Norfolk Boreas Offshore Wind Farm Updated Joint Position Statement Noise Sensitive Receptors

Applicant: Norfolk Boreas Limited
Document Reference: ExA.AS-2.D7.V2
Deadline 7

Date: March 2020
Revision: Version 2
Author: Royal HaskoningDHV

Title:
Noise receptor locations (Map 8 of 9)

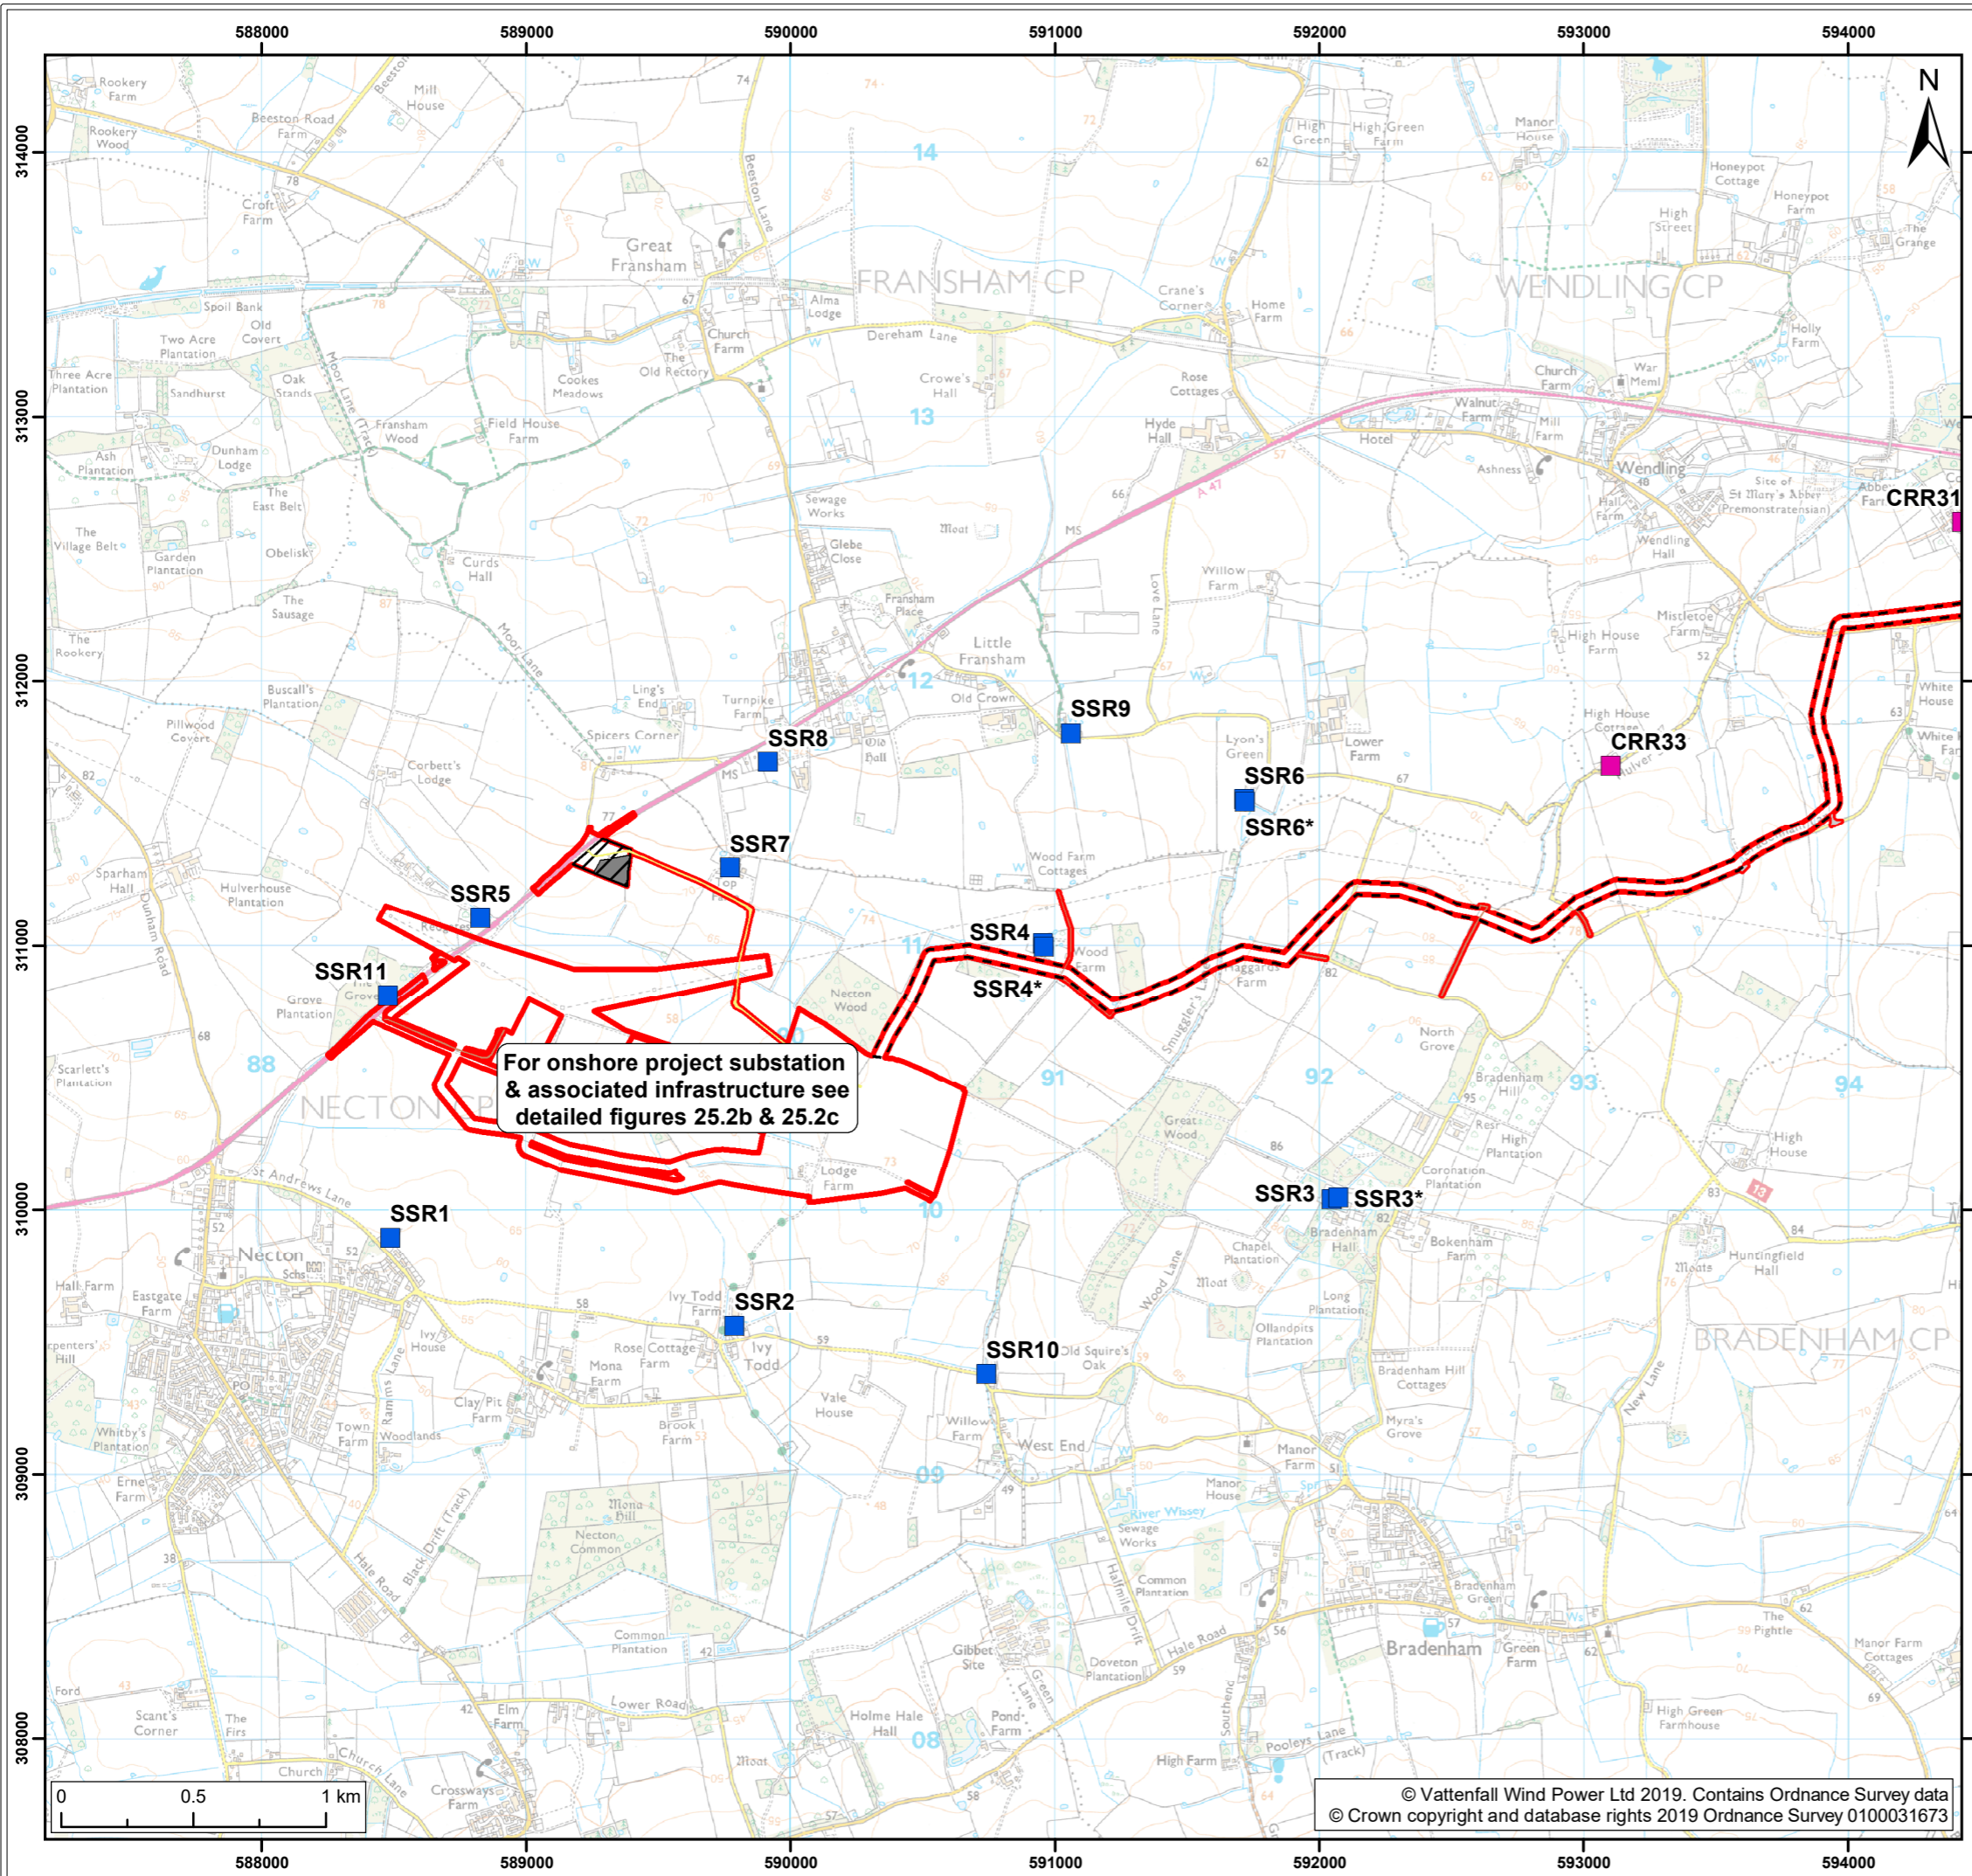
26. BDC have raised concerns with the appropriateness of the position of sensitive receptors and draw attention to the following:
 - a) *Flashpit Farm cottages at Blickling are close to the cable route.*

- b) *CRR12 is not representative of the noise environment at Beerhouse Farm Cottage.*
 - c) *CRR15 and 16 do not appear to represent the impact for dwellings in World's End Lane.*

- d) *CRR17 does not seem an appropriate NSR as the cable route has been moved.*

27. BDC have also requested confirmation that cable route construction impacts have been considered at all sensitive receptors.
28. Clarifications on these concerns are raised below. Full details are provided in ES Chapter 25 [APP-238], all identified receptor locations are shown on ES Figure 25.2 [APP-470] and details of the baseline noise survey is presented in ES Appendix 25.1 [APP-657].

Flashpit Farm Cottages – the nearest residential receptor (represented by building at co-ordinates x: 618415, y: 327870) to the cable route is located along Blickling Lane at approximately 70m setback distance from the cable route. Receptor CRR13 is approximately 54m from the cable route, so represents a conservative proxy location. From the baseline noise survey undertaken as part of the ES (detailed in Table 2 and Table 3) CRR13 would fall within the threshold category A as defined in BS5228:2009+A1:2014 (British Standards Institution [BS] 5228-1:2009+A1:2014 “Code of practice for noise and vibration control on construction and open sites – Part 1: Noise) ‘ABC method’ during the daytime, evening and weekends and night time reference periods (detailed further in Section 25.4.1 Impact Assessment Methodology of the ES Chapter 25). No impacts were predicted as receptor CRR13 during the construction phase; therefore it would be reasonable to infer the same at the nearest residential property forming the Flashpit Farm Cottage receptors.

Beerhouse Farm Cottage (represented by the building at co-ordinates x:614214, y: 325449) – nearest residential building is approximately 19m from the cable route. CRR10 and CRR11 are approximately 8m and 33m respectively from the cable route. Therefore, it is confirmed that the range of setback distance of the assessed receptors in the ES Chapter is considered to be representative. The predicted noise levels reported for CRR10 and CRR11 would represent a reasonable worst-case scenario.

The soundscape at Beerhouse Farm is considered to be similar to CRR10 and CRR11, due to the proximity to the carriageway. The construction phase threshold category is A (65dBA) during the daytime and during the evening and night time 55dBA, and 45dBA, respectively. Further, the measured baseline noise levels presented in ES chapter Appendix 25.1 are shown in Table 2 and Table 3:

No Impacts were predicted at the nearest receptors reported in the ES Chapter 25 and it is reasonable to conclude the same for the additional receptors identified by BDC.

The soundscape at receptors along Worlds End Lane is considered to be comparable with the baseline noise measurements obtained at location CRR16 during the survey. The residential properties are a similar setback from the B1145 to CRR15 and CRR16. All fall within the threshold category A as defined in BS5228:2009+A1:2014 (British Standards Institution [BS] 5228-1:2009+A1:2014 “Code of practice for noise and vibration control on construction and open sites – Part 1: Noise) ‘ABC method’ during the daytime, evening and weekends and night time reference periods (detailed further in Section 25.4.1 Impact Assessment Methodology of the ES Chapter 25).

The nearest receptor along Worlds End Lane (represented by the building at co-ordinates x: 610013, y: 323806) is approximately 20m from the proposed cable route, a similar setback distance to receptor CRR3F (approximately 20m). A moderate impact was predicted at receptor CRR3F during daytime preconstruction works and Cable pulling, joint and commissioning, with a minor impact predicted during duct installation. It is reasonable to assume the magnitude of impacts would be similar at the receptor along Worlds End Lane.

As a result of adaptations to the project design and onshore cable route some baseline receptor locations, such as CRR17, became redundant. However, the predicted noise levels from all previously identified and agreed receptors (as agreed through expert topic group and as part of the evidence plan process) were included in ES Chapter 25 for transparency.
